Ribble Valley Borough Council
Housing & Development Control

Your ref 3/2021/1154
Our ref
Date 09 December 2021

Planning Application No: 3/2021/1154
Proposal: Loft conversion with side-facing dormer.
Location: 27 The Hazels Wilpshire BB1 9HZ

14 L2 Loft FFE Proposed  
1 : 100

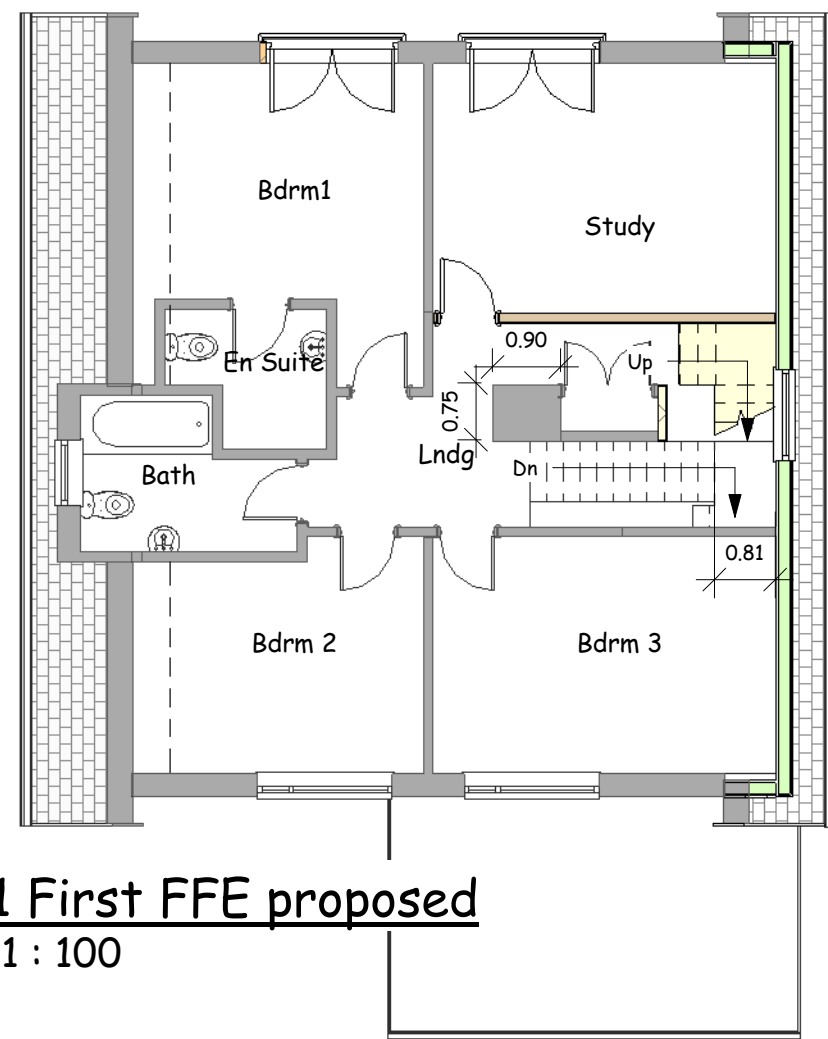
The proposal increases the property from a 3 bedroom to a proposed 5 bedroom property with this loft conversion.
